**PRELIMINARY DRAINAGE REPORT AND MDDP ADDENDUM
FOR
HOMESTEAD NORTH AT STERLING RANCH PRELIMINARY PLAN**

Engineering Review

04/23/2021 5:49:58 PM

PCD Filing No.:

HOMESTEAD NORTH AT STERLING RANCH
EARLY GRADING & EROSION CONTROL PLAN

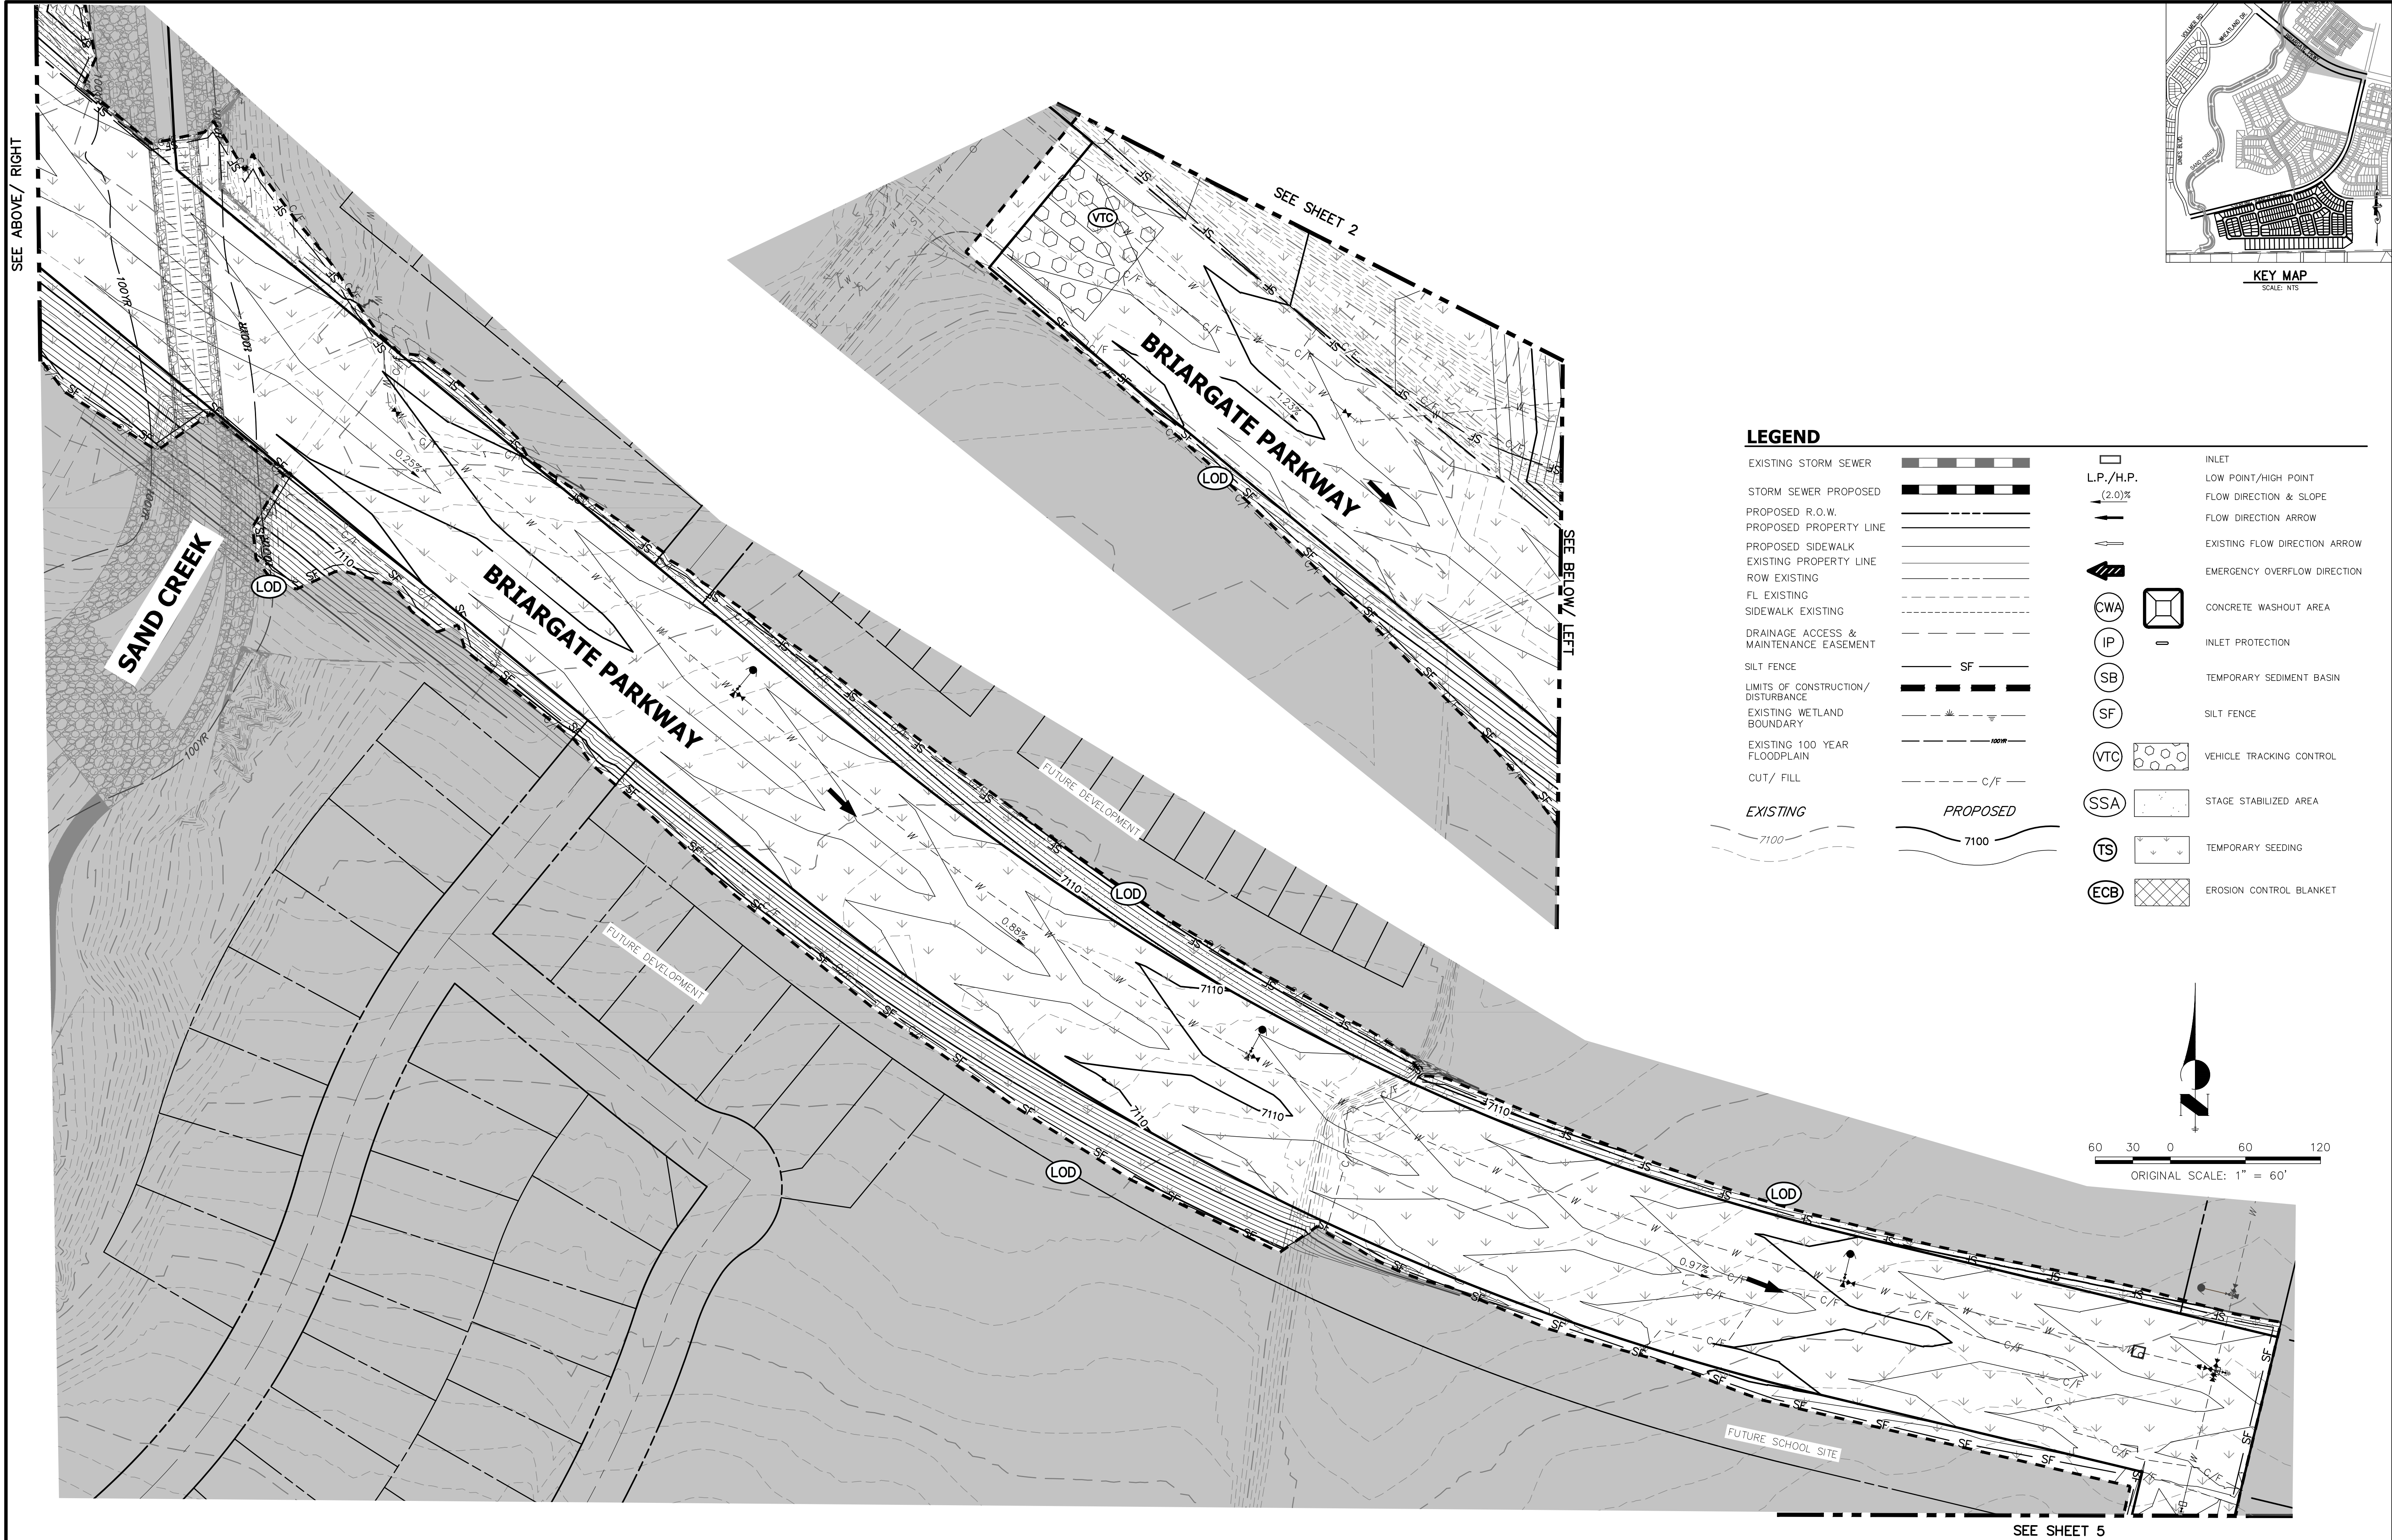
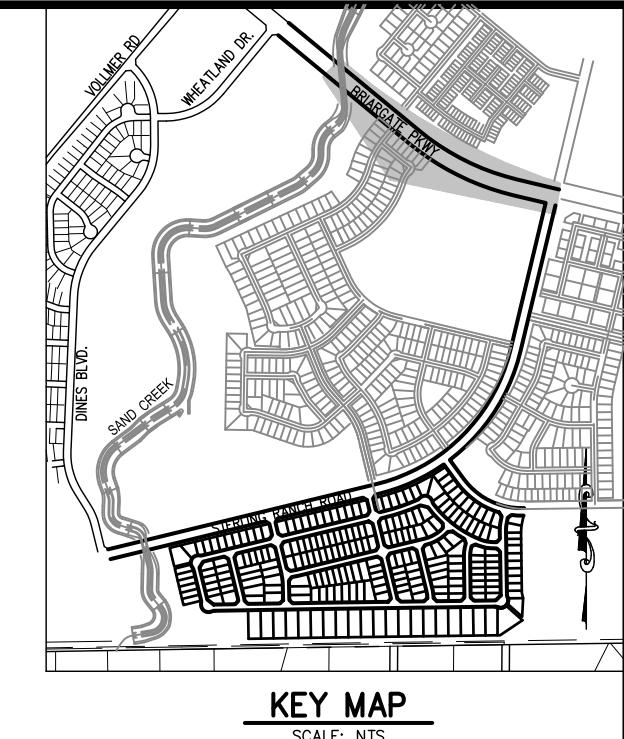
If Briargate Pkwy and Sterling Ranch Road are included in early grading, details to the FDR level will be required. See comment letter.
